Application No: AB/44/21/HH
Site Address: Fern Cottage 5A Surrey Street Arundel BN18 9DT
Description of works: Proposed loft conversion (This application may affect the setting of the Arundel Conservation Area).

Thank you for your internet representation made on 16th May 2021 which has been recorded as an objection with the comments as follows:

Existing South Elevation

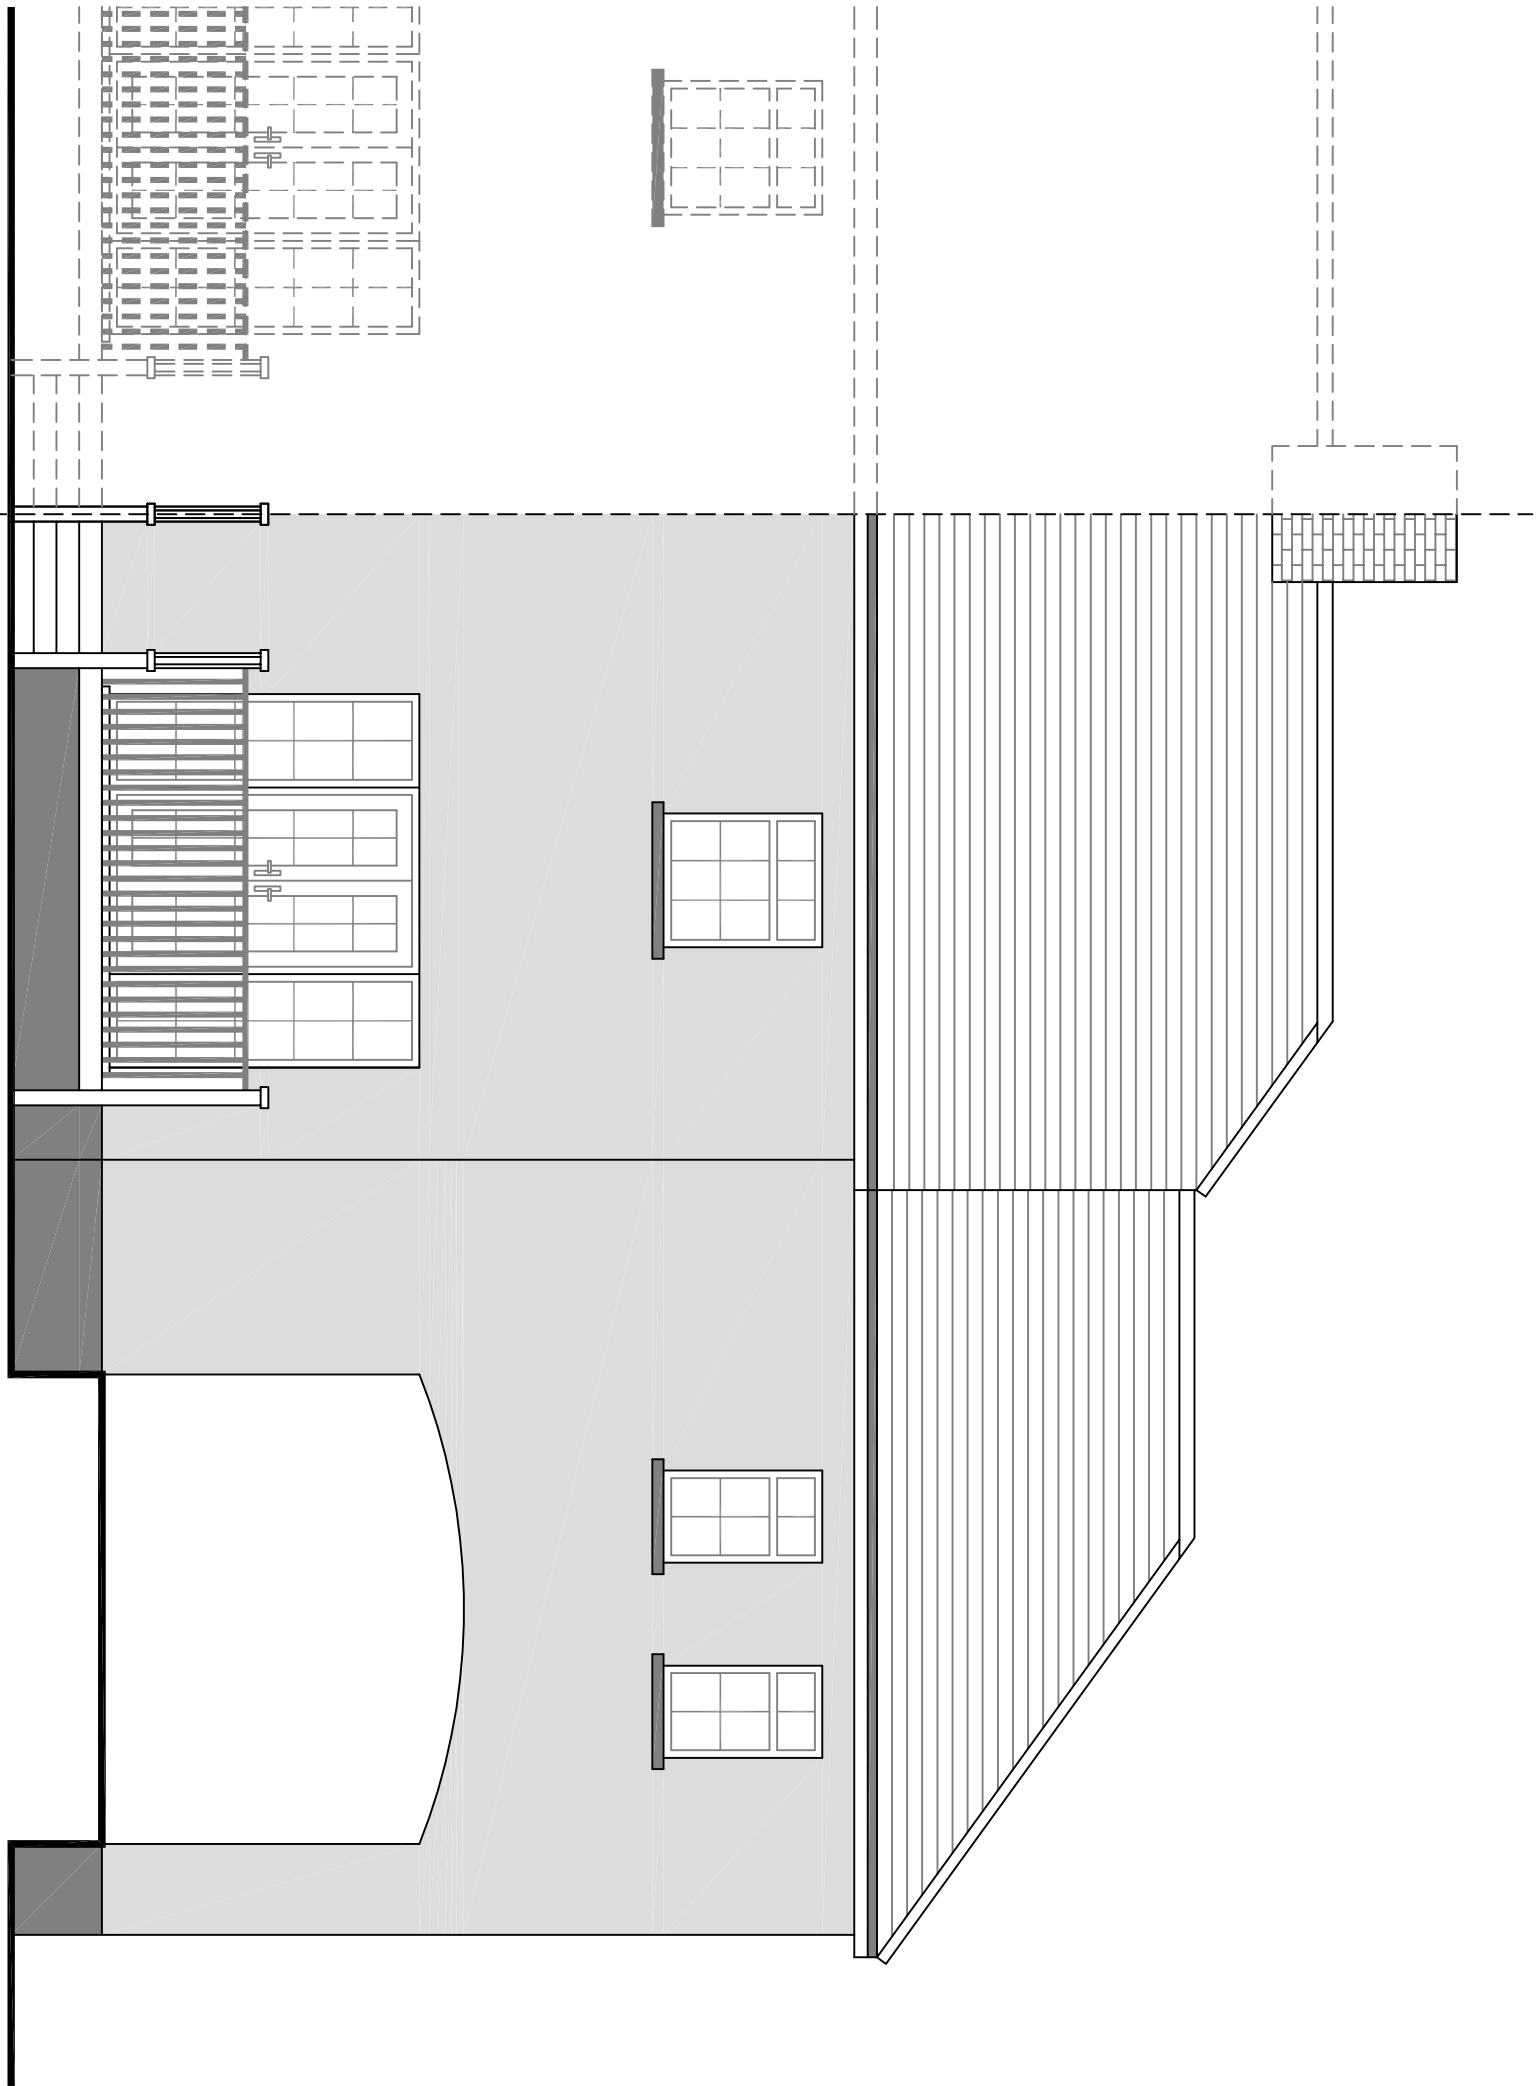
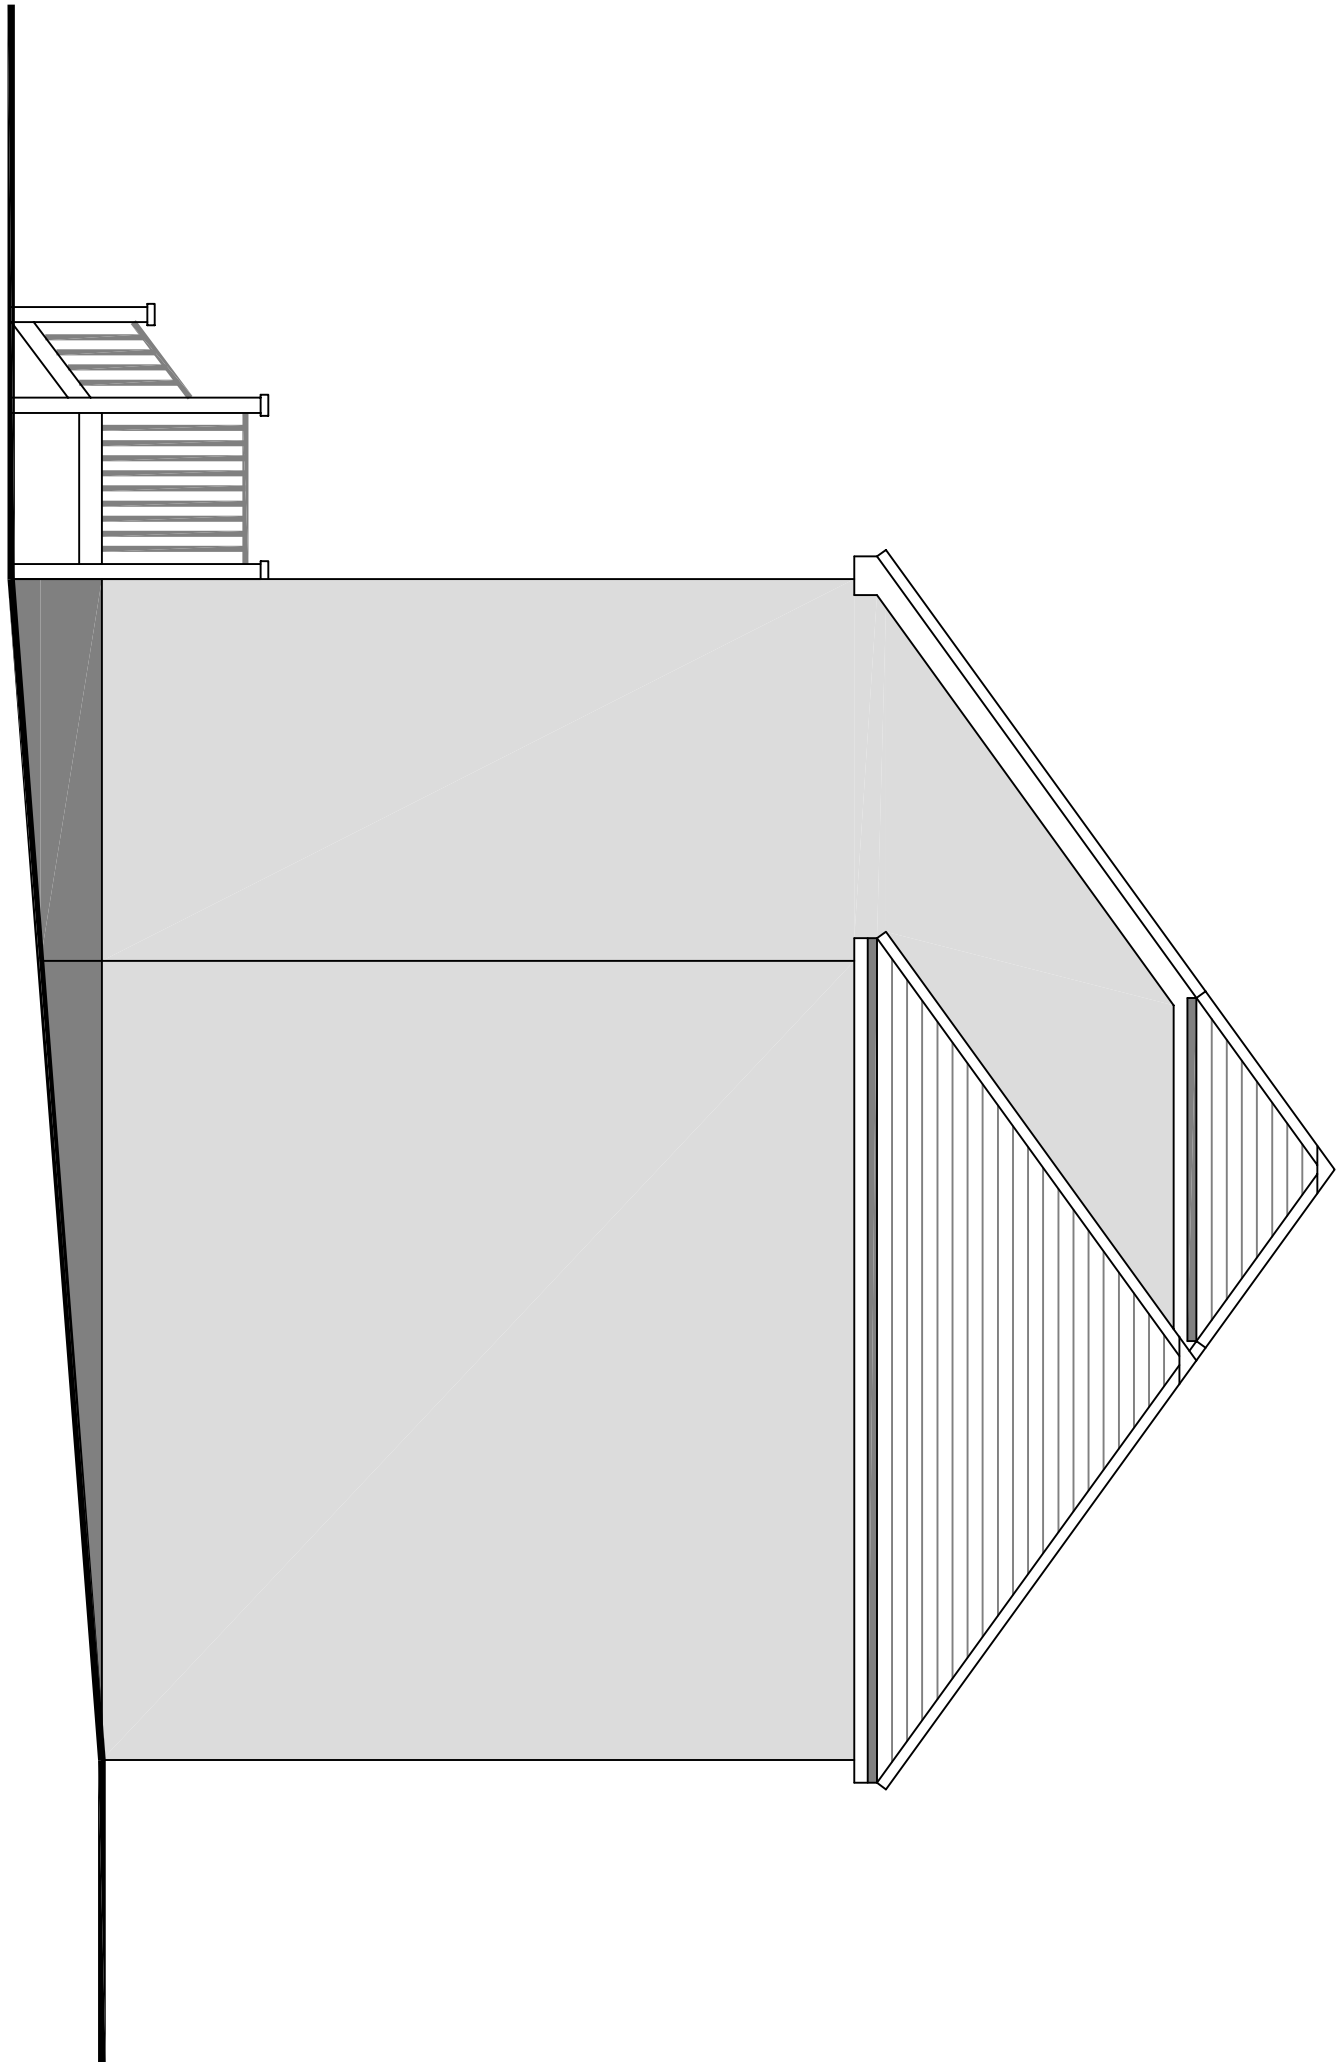
It should be noted that the existing vertically sliding sash windows (6 panes over 6) are not correctly portrayed on the elevational drawings and it is important that if any planning permission should be granted it does not inadvertently include the replacement of these appropriate windows with inappropriate ones.
